Our Ref: A/11/11/L

Application for Listed building consent for repairs to existing walls and roof structure and replacement of existing gutters and downpipes

Old Forge House Arundel Road Angmering BN16 4JZ

Existing Floor Plan.
(Showing structure over)
(1:50)

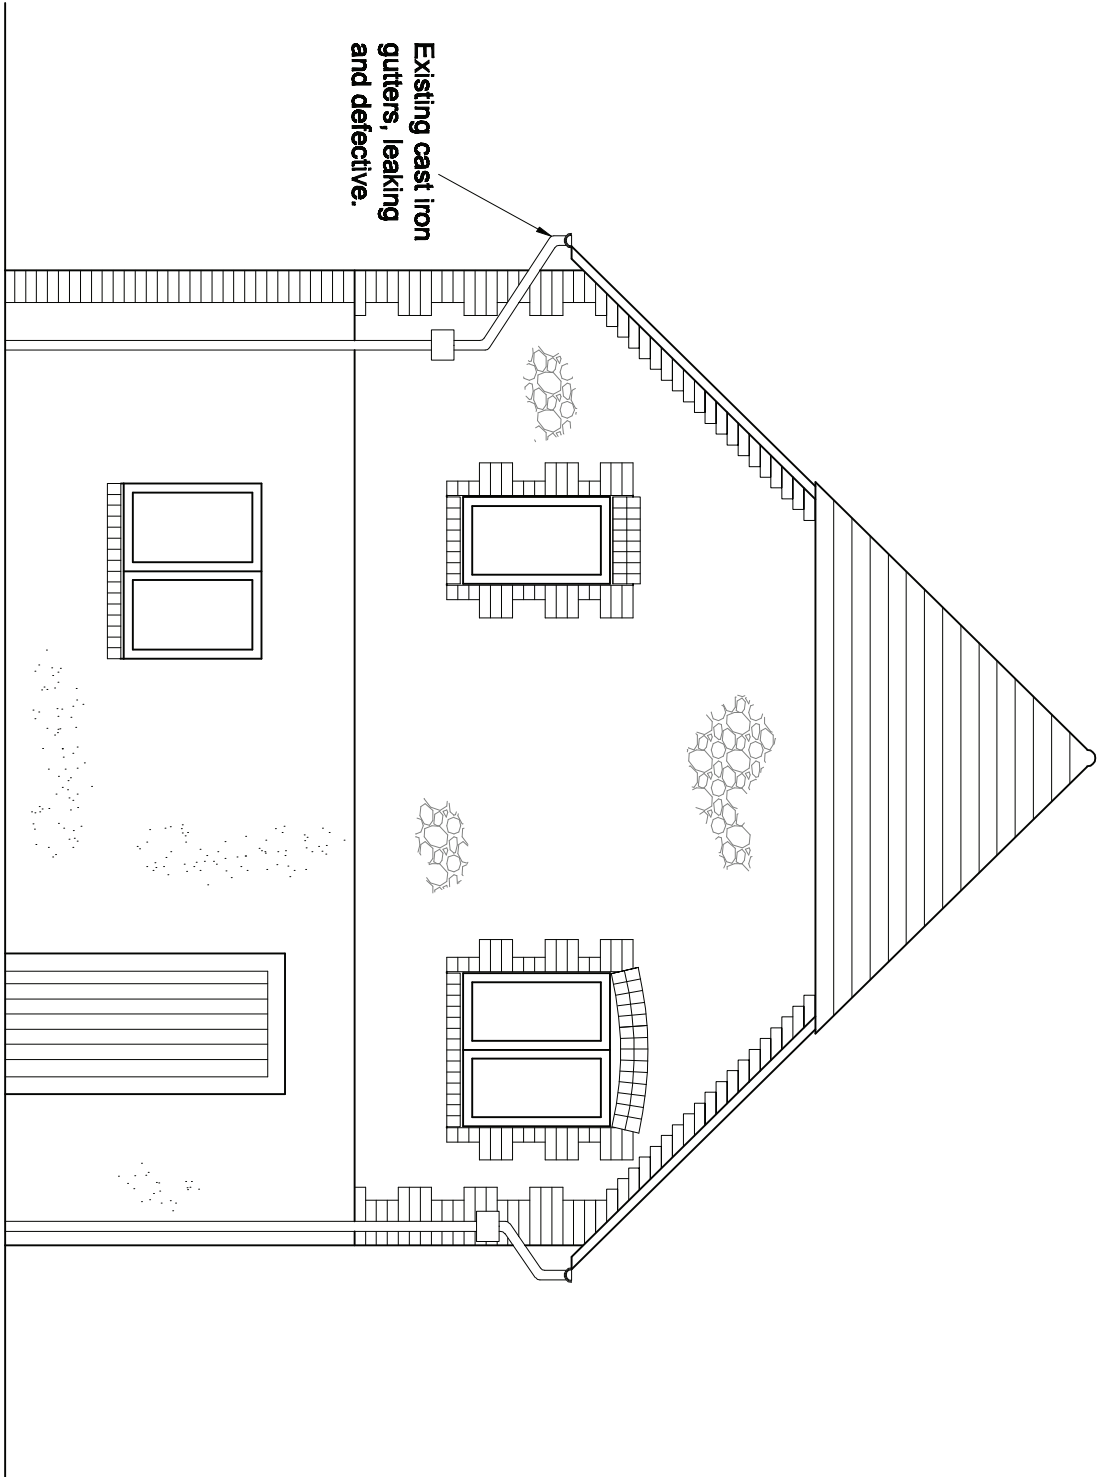
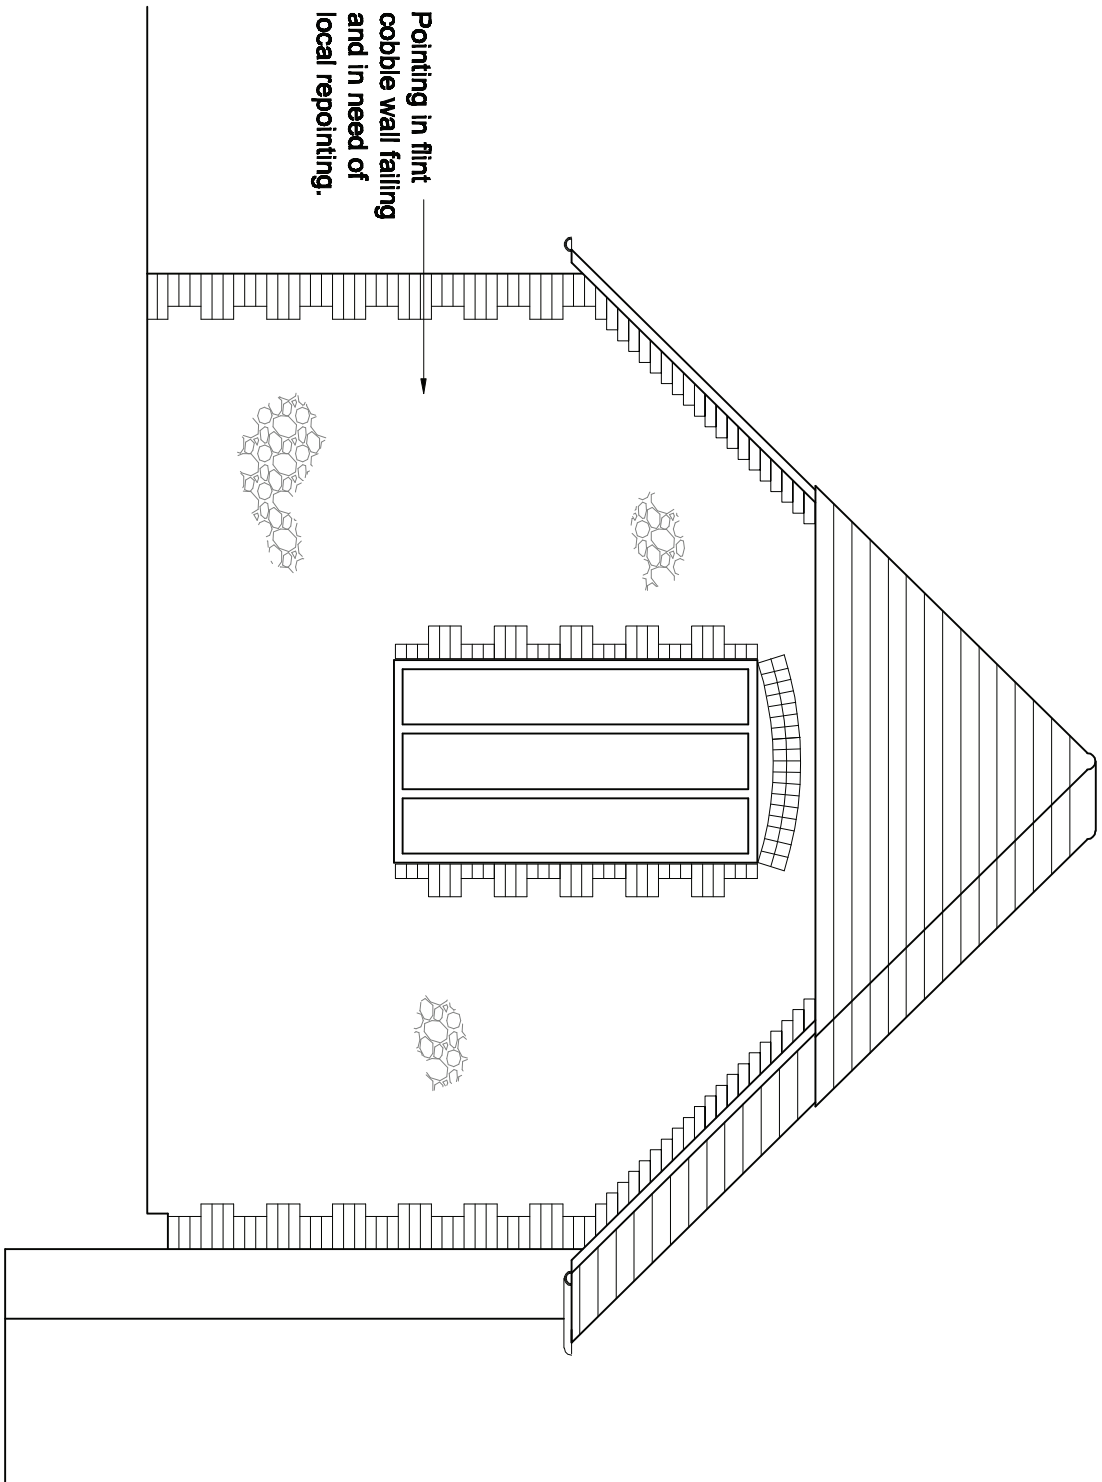
Please provide 1 electronic or 3 paper copies of revised existing and proposed floor plans. There is a window shown on the north elevation which is not shown on the floor plans.

1. The Location Plan has been revised to include two named roads adjacent to the building in accordance with your guidance notes.
2. The Block Plan has been revised with red edging to highlight the position of the site and hatching showing the position of the proposed works.
3. The existing and proposed floor plans have both been revised to include the window on the north elevation.
